Our reference: P-802538-M6M6
Contact: Robert Walker
Telephone: 4732 7409

19 December 2024

**Council Response to Environmental Impact Statement – SSD-70316465 –
Burra Park Warehousing and Logistics Estate at 1953-2109 Elizabeth Drive,
Badgerys Creek**

Figure 8 Stormwater Infrastructure Comparison

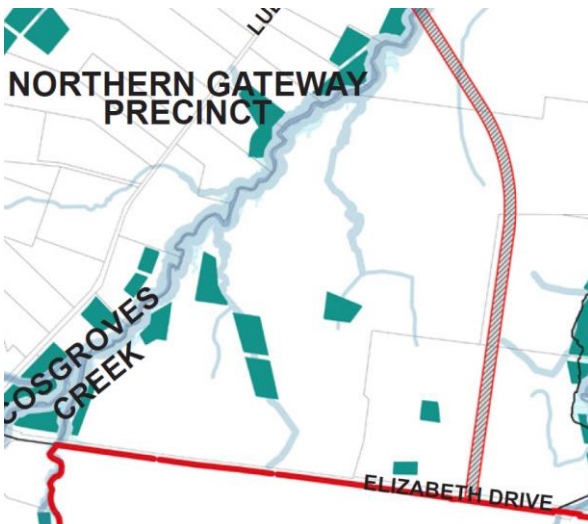
- i) The application proposes variations to the Water Cycle Management Plan, shown in the Western Sydney Aerotropolis Precinct Plan 2024. The application indicates that consultation has occurred with Sydney Water, however it is expected that associated specific endorsement be provided in this regard.

Figure 2. Stage 1 concept masterplan

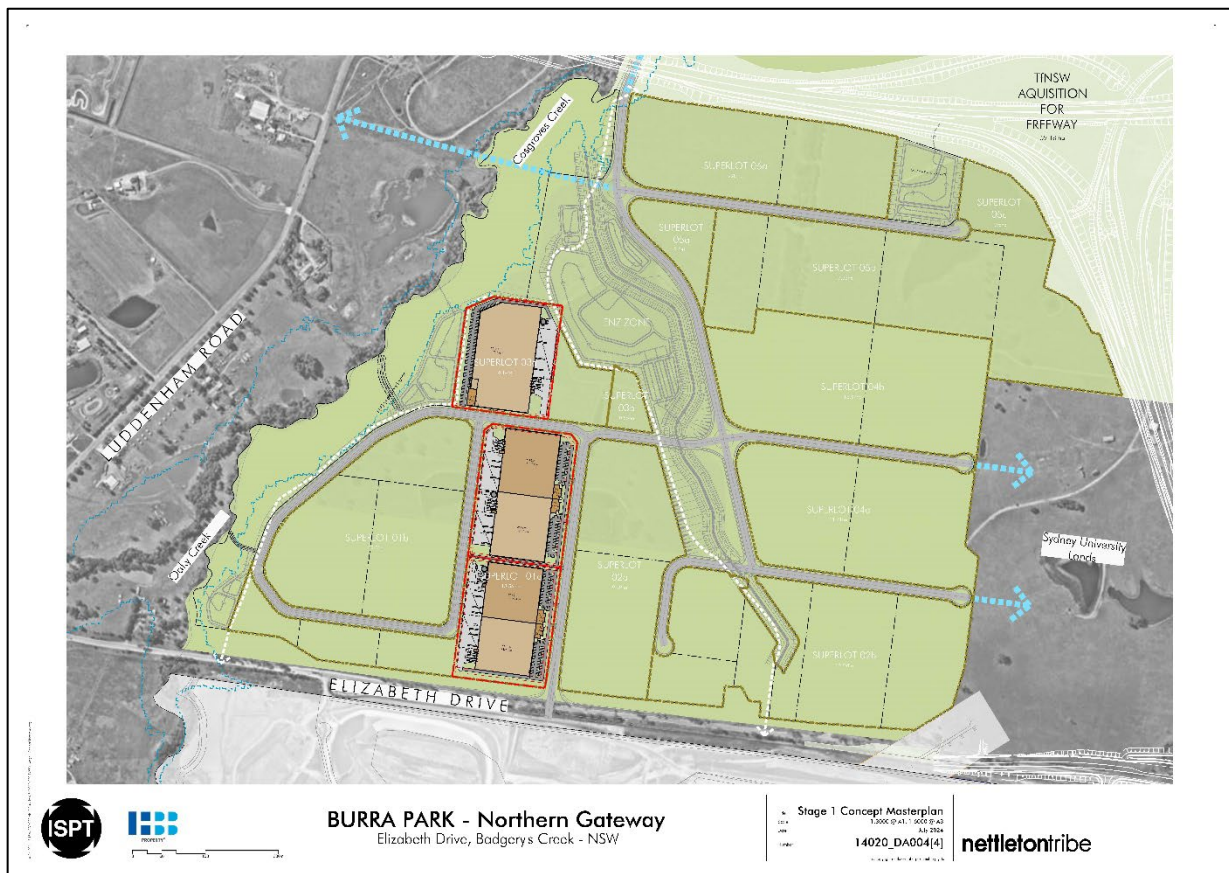
- l) It is noted that the 'Stage 1 works' on Lots 1.1, 1.2 and 3.1, propose on-lot stormwater detention basins in accordance with the estate stormwater management strategy. It is expected that any such Development Consent which may be granted, include conditions of positive covenants and restrictions as to use, for the maintenance of stormwater infrastructure on private land in perpetuity.

- m) Swept path diagrams for the development of Lots 1.1, 1.2 and 3.1, have not been provided for review. It is expected that careful consideration be given to overall vehicle circulation and manoeuvring matters, having regard to applicable provisions (including of Part 3.2 of the Western Sydney Aerotropolis Development Control Plan 2024).
